COMPREHENSIVE OBJECTION TO AMENDED STATE SIGNIFICANT DEVELOPMENT APPLICATION

**SSD-83478456 — Residential Development with In-fill Affordable Housing
21, 23 and 25 McIntosh Street and 55 Werona Avenue, Gordon**

Date: 9 June 2026

Submitter: Owner of 12 Forsyth Street, Killara/Gordon (this submission updates earlier submission ref: SUB-92392706).

B

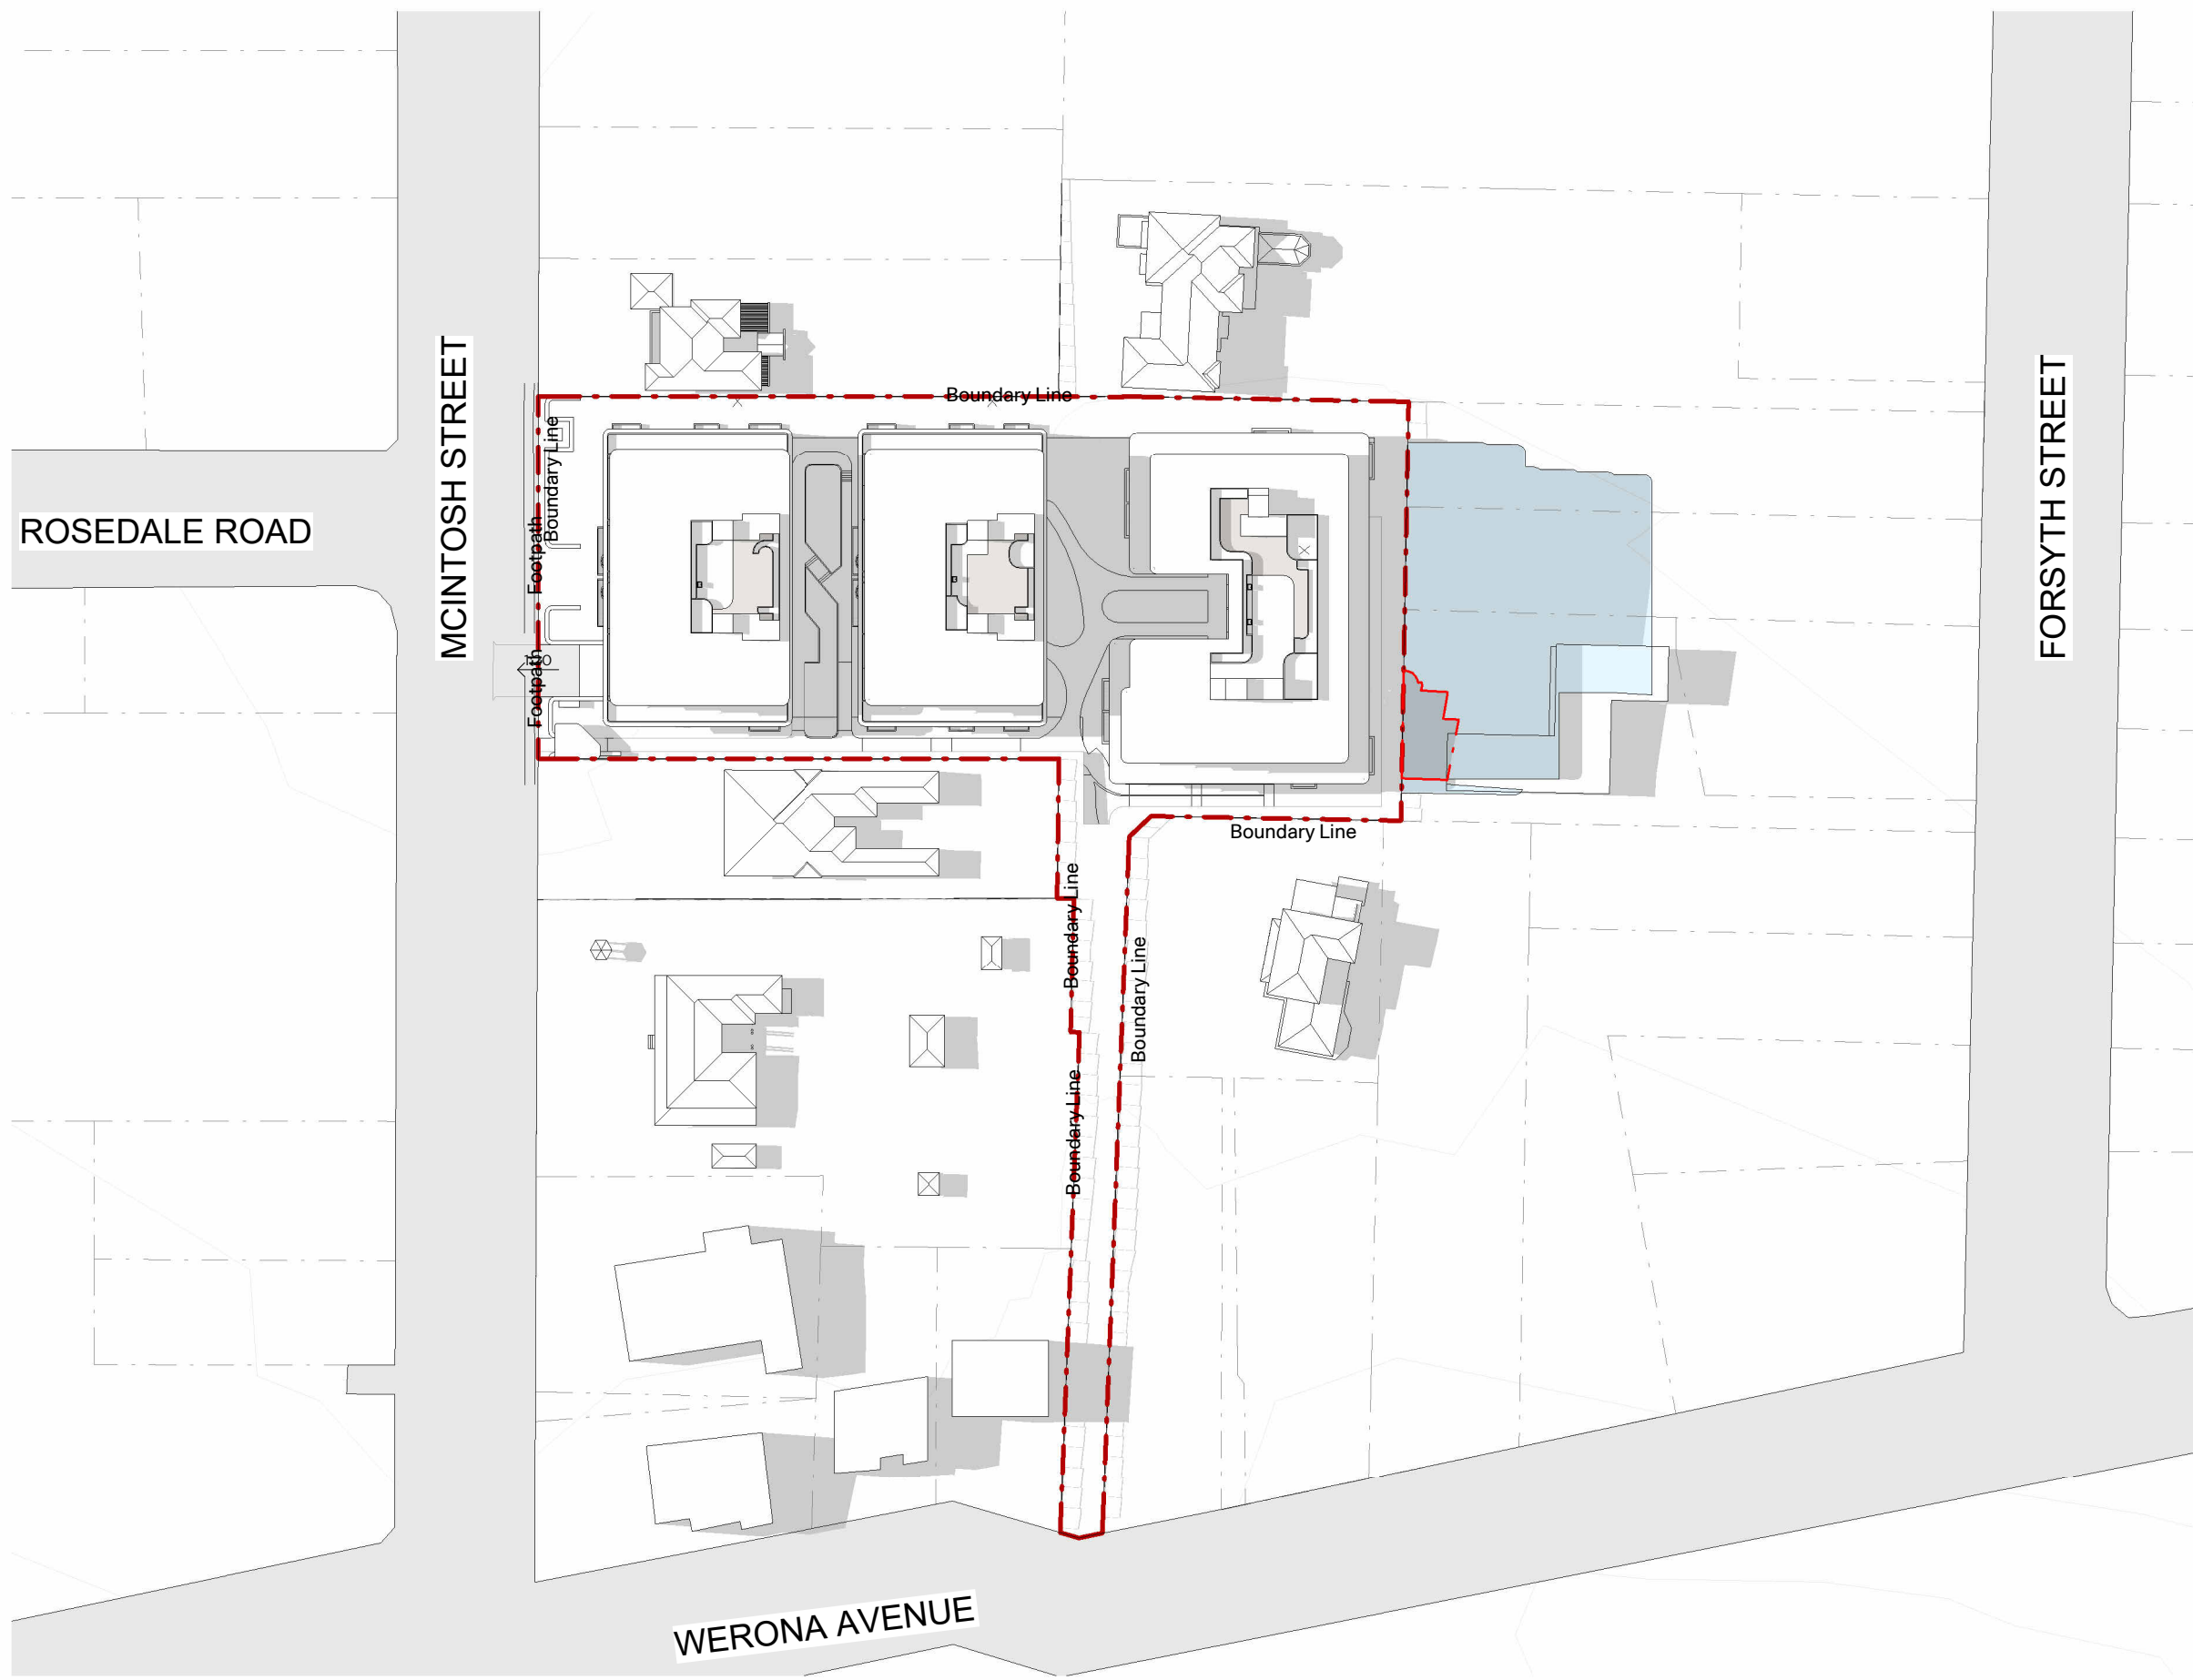
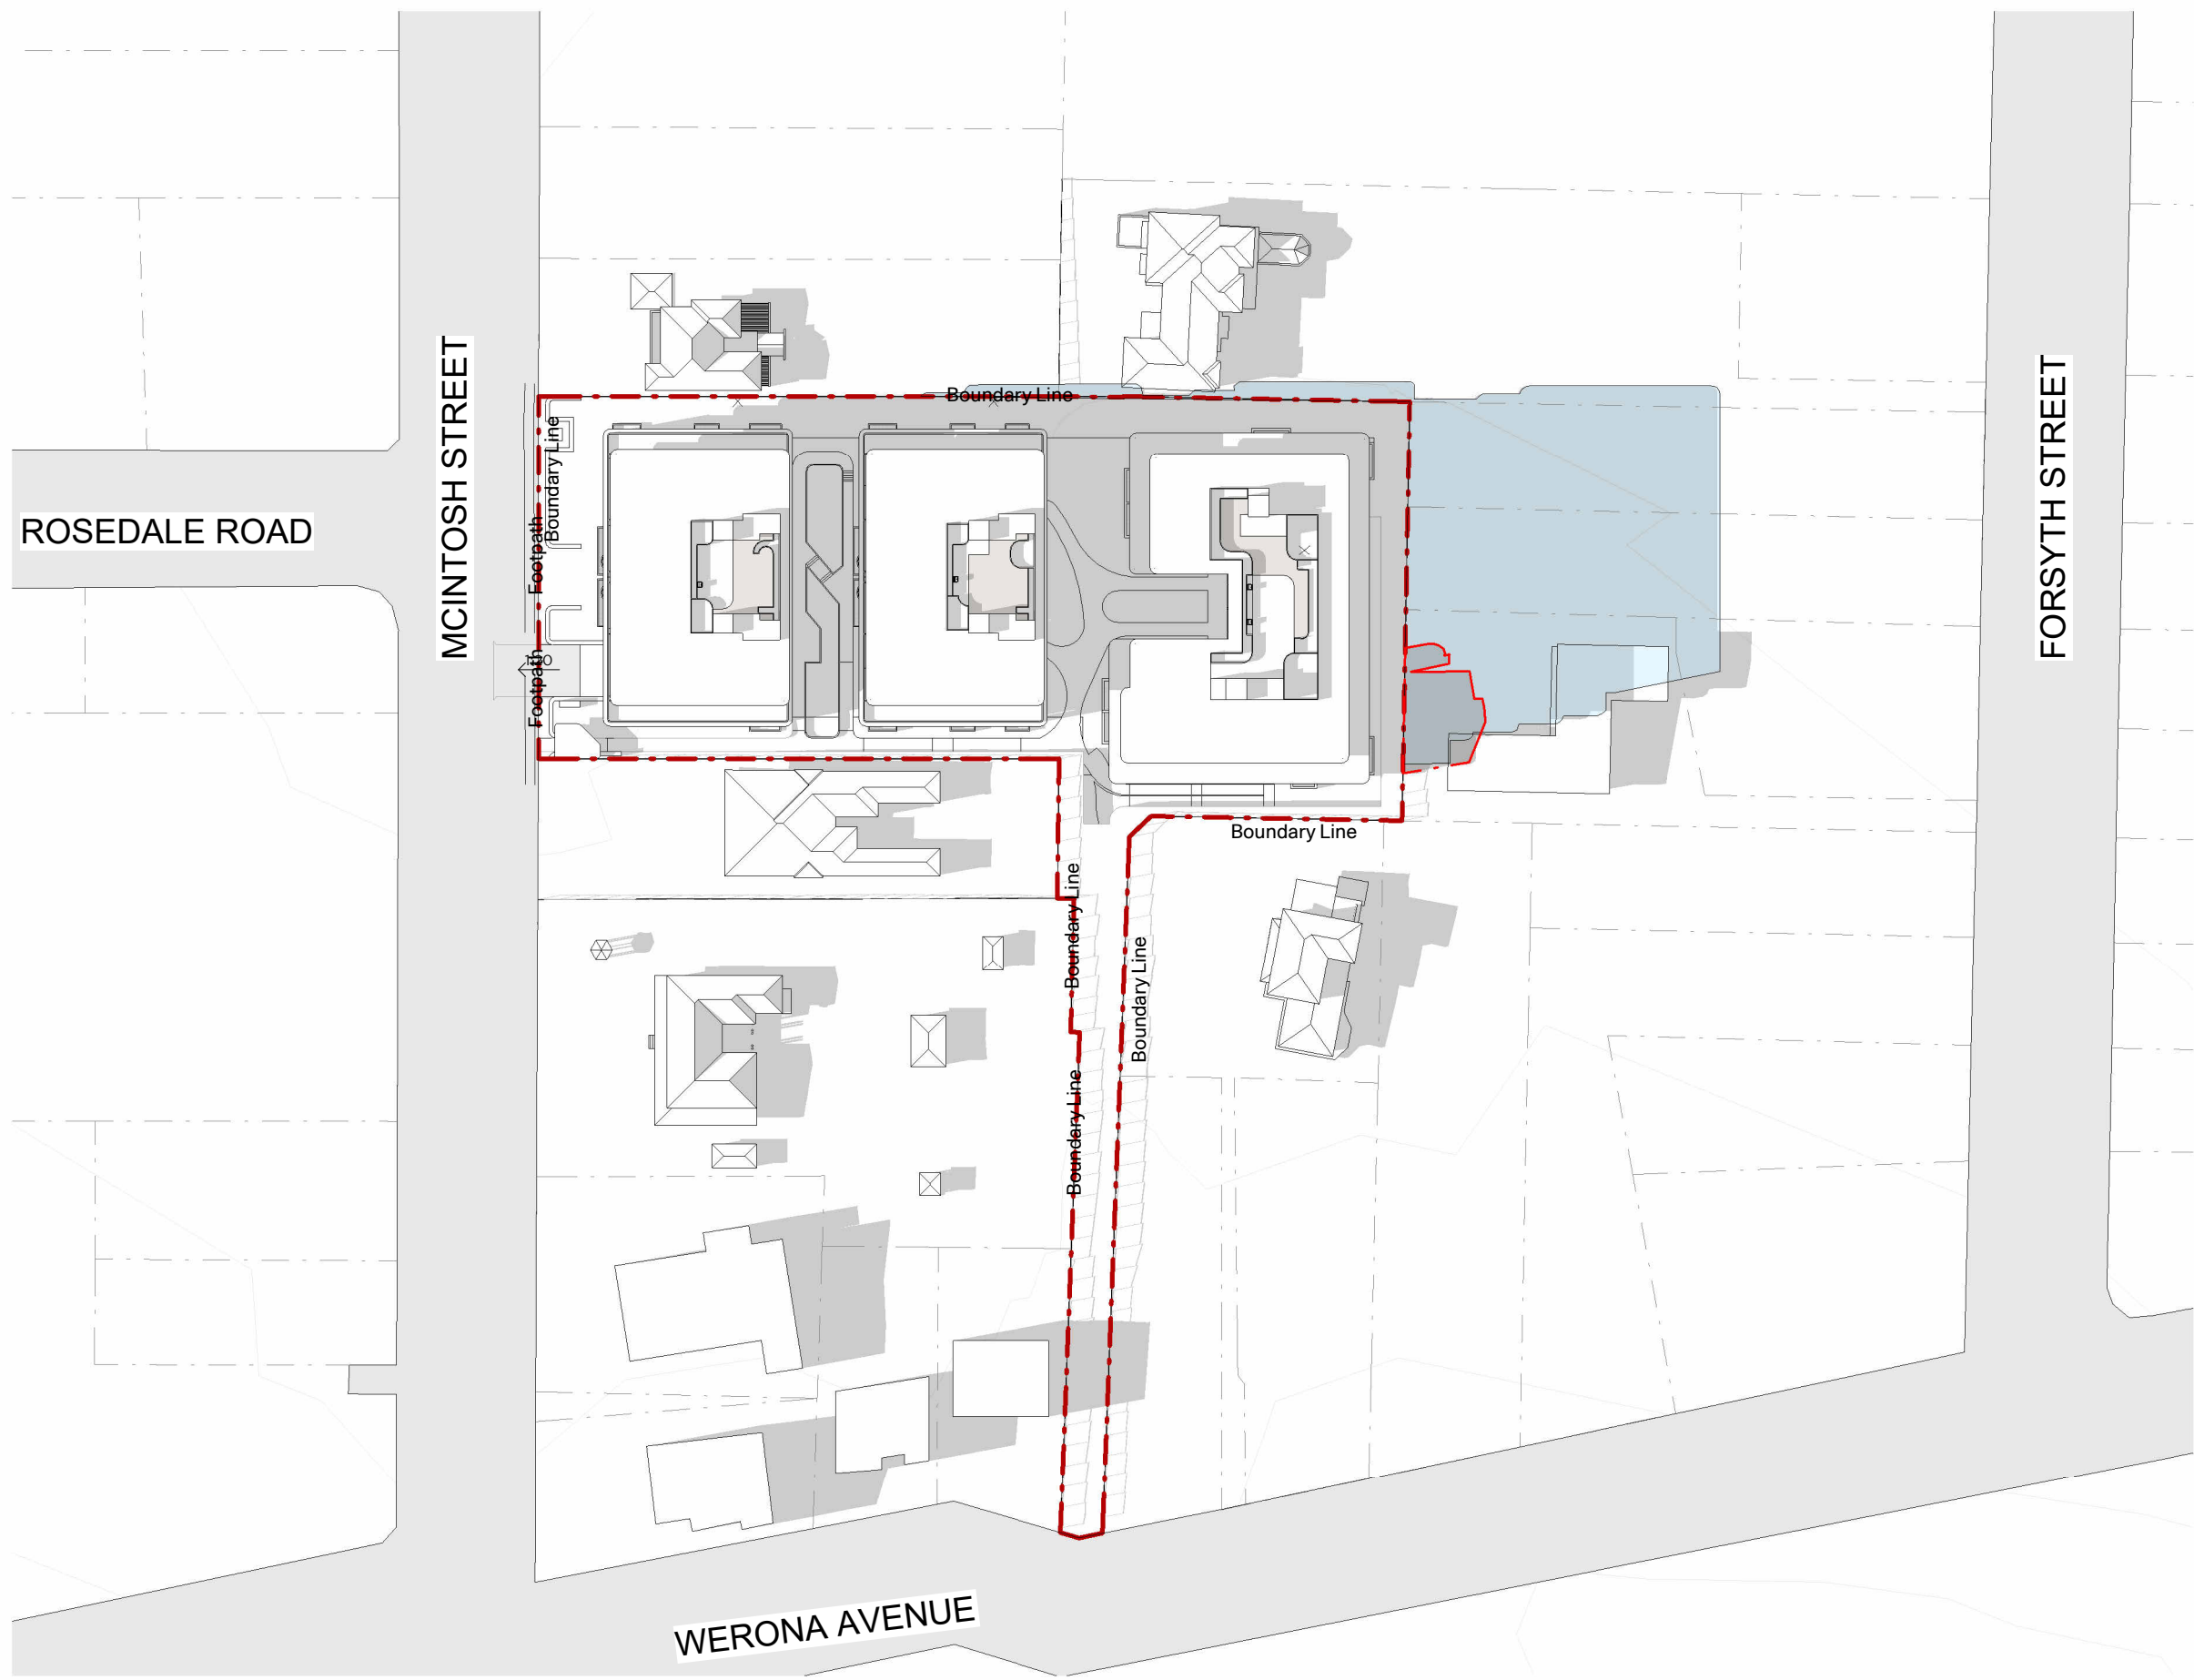
This is the central direct impact on my property. The applicant's own Amendment Report states that 12 Forsyth Street experiences additional overshadowing from the proposed development, that not all parts of the dwelling receive two hours of direct sunlight between 9am and 3pm on 21 June, and that only one primary frontage and a nominated 25 sqm private open space area receive some solar access — while acknowledging this does not fully satisfy the prescriptive controls. The report concedes the proposal does not achieve full compliance with the solar access controls for 12 Forsyth Street in its current form.

This is not a matter of subjective neighbour preference. It is a direct admission that my dwelling is adversely affected. The applicant characterises the impact as “minor” or “partial”; that characterisation should be rejected and the shadow analysis independently verified against my approved two-storey plans. I note the applicant's Stormwater Plans (Appendix P) still describe my property as a “Single Storey Brick Residence Under Construction,” while the architectural plans treat it as two-storey — the shadow and amenity baseline is internally inconsistent and unreliable.

The Department should require the applicant to redesign Building C to remove the non-compliant solar impact — reducing Building C, removing or relocating Level 8 / rooftop communal open space, increasing the southern setback, and providing verified, plan-based shadow diagrams for the actual approved dwelling, living areas, windows and principal private open space at 12 Forsyth Street.
